From: Laura Gibbons
Sent: 15 August 2018 12:21
To: Planning.Responses
Subject: RE: Please find attached amendment on planning application Ref: R/267/17/PL

Engineers Comments Regarding Surface Water Drainage

APPLICATION NO: R/267/17/PL

Description of Works: 2 storey block of 6 No Flats comprising of 4 No. 2 bed & 2 No. 1 bed flats.

EXISTING SITE PLAN and Existing
Drainage
Rustington Hall
Station Road
Rustington
BN16 3AY

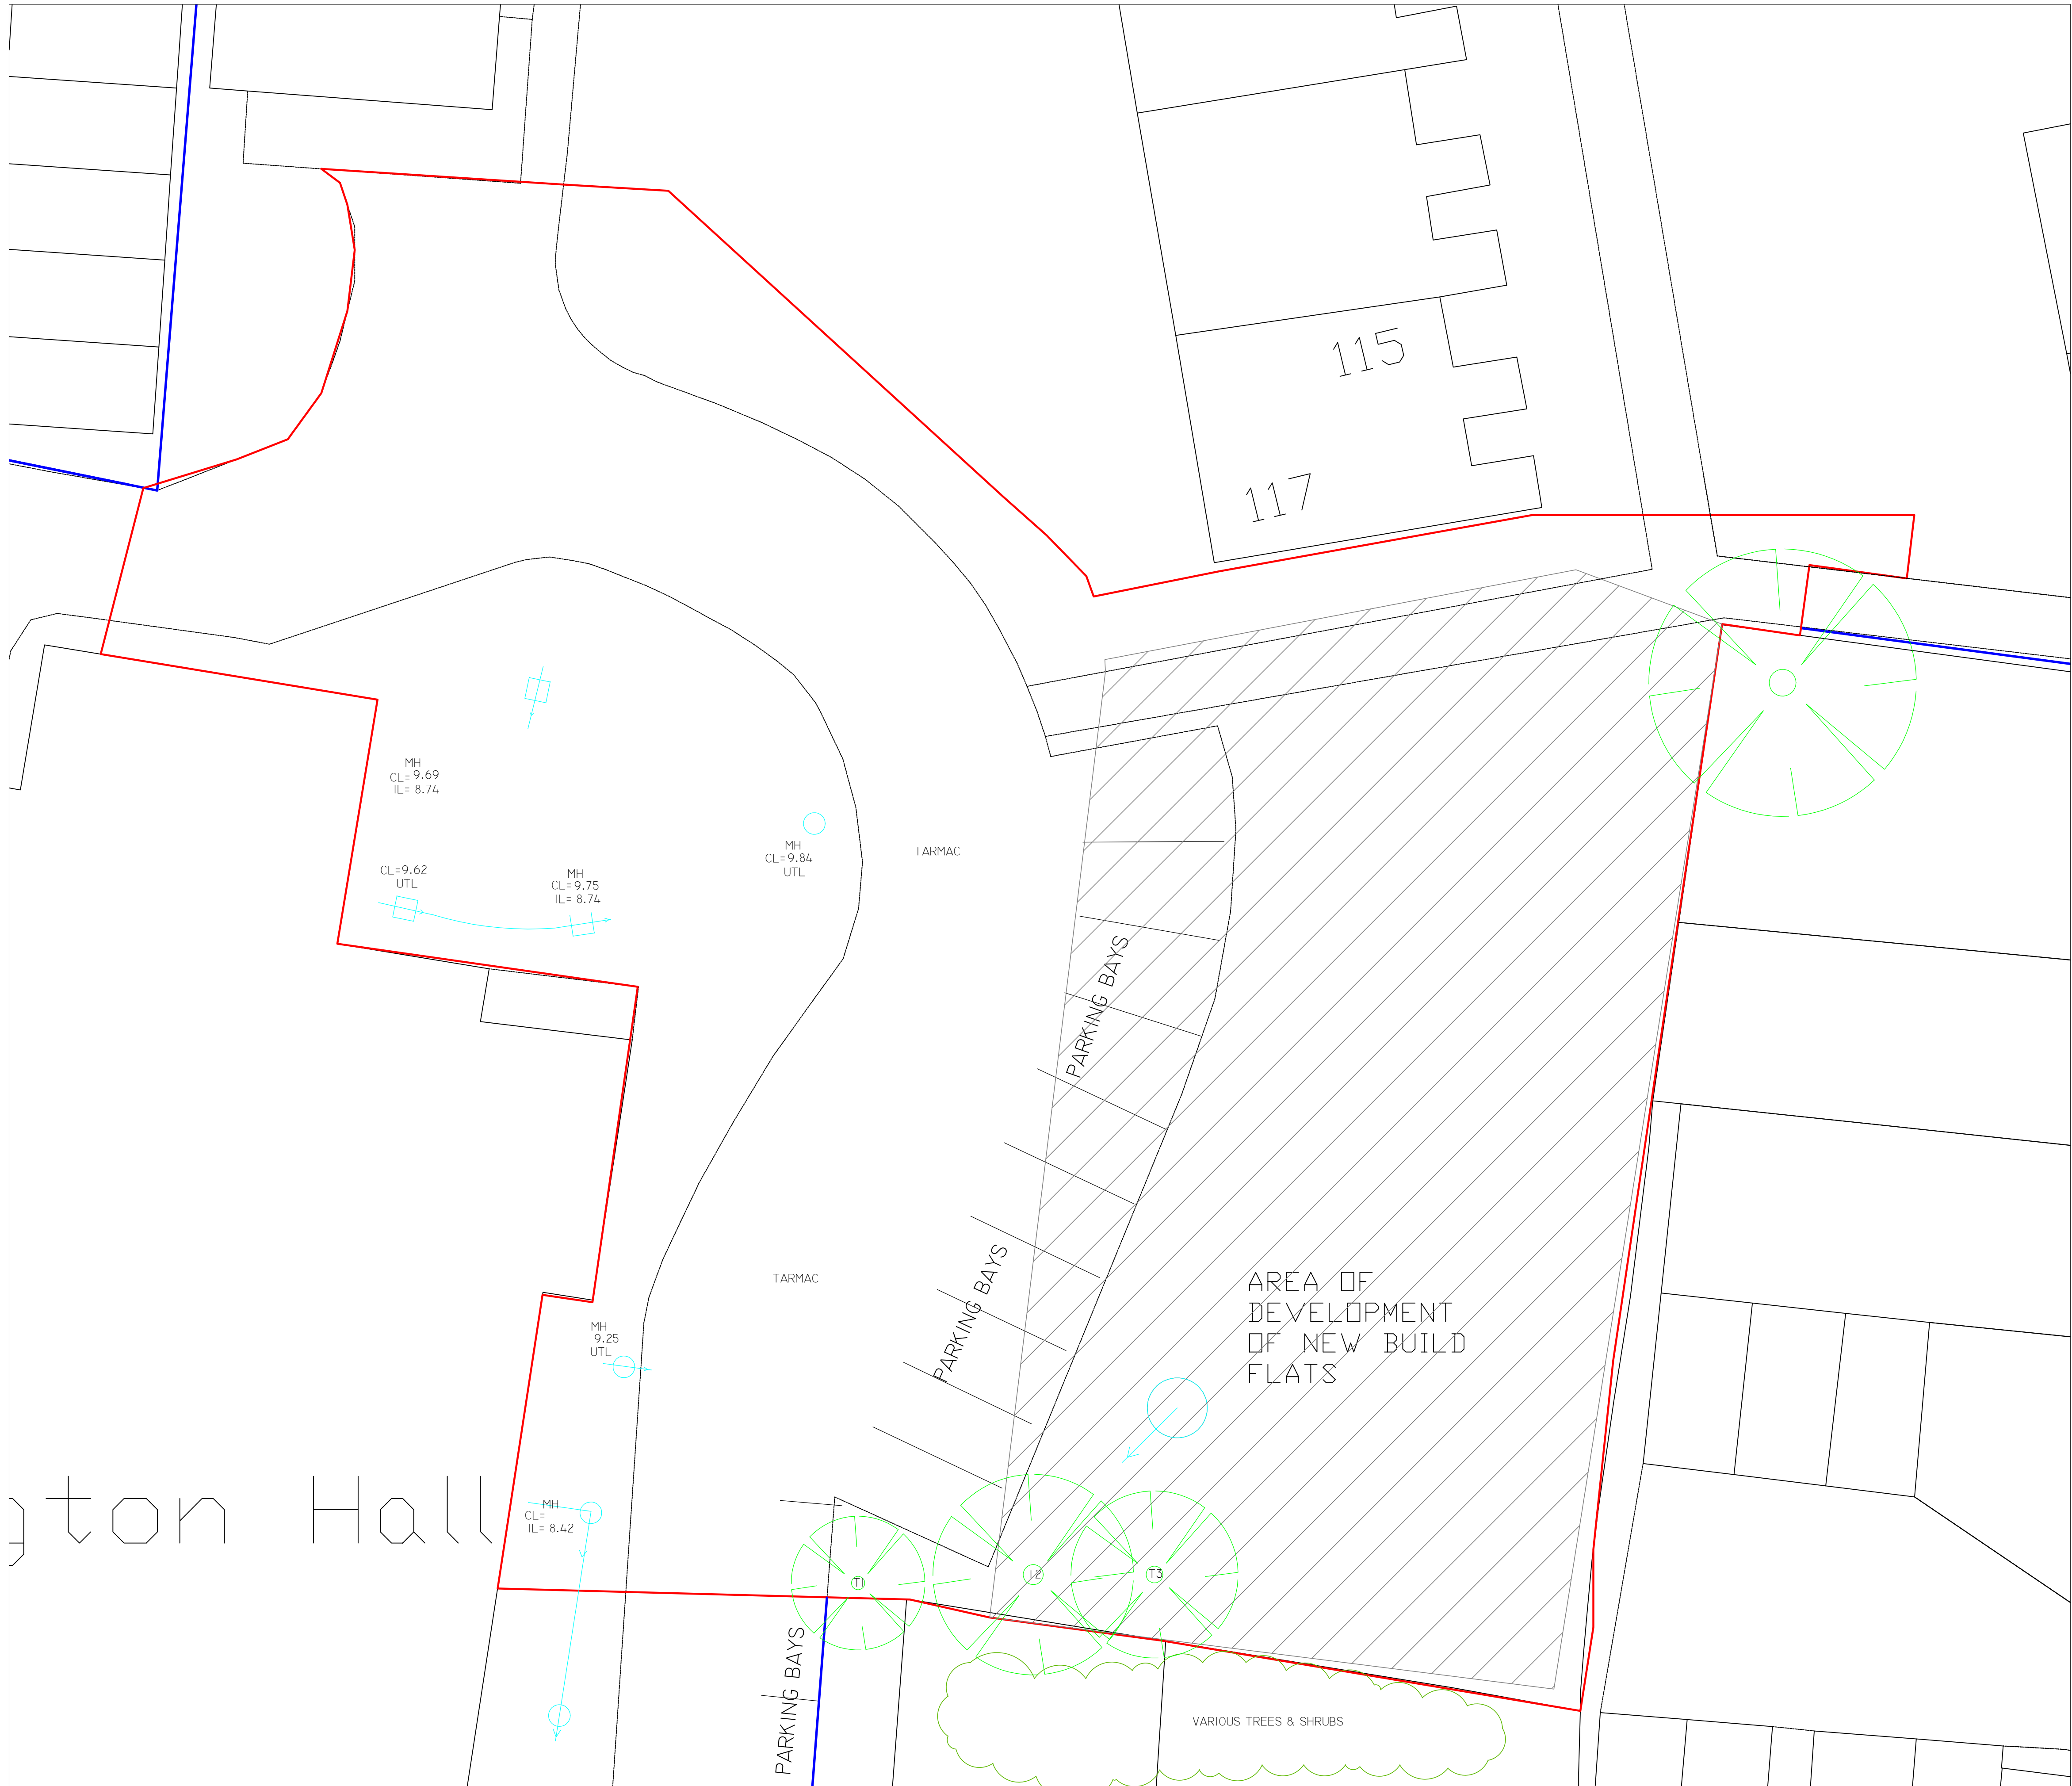
The surface water drainage design seems unclear and to be a significant variation to that supplied previously. It now seems to be proposed to connect to an existing surface water network.

It will need to be demonstrated that infiltration doesn't work, flows are attenuated, and that there is sufficient capacity within the existing surface water network to take this attenuated flow.

When the applicant wishes to discharge the condition we will need to see: winter groundwater monitoring results, winter infiltration testing results, calculations, detailed plans and construction details.
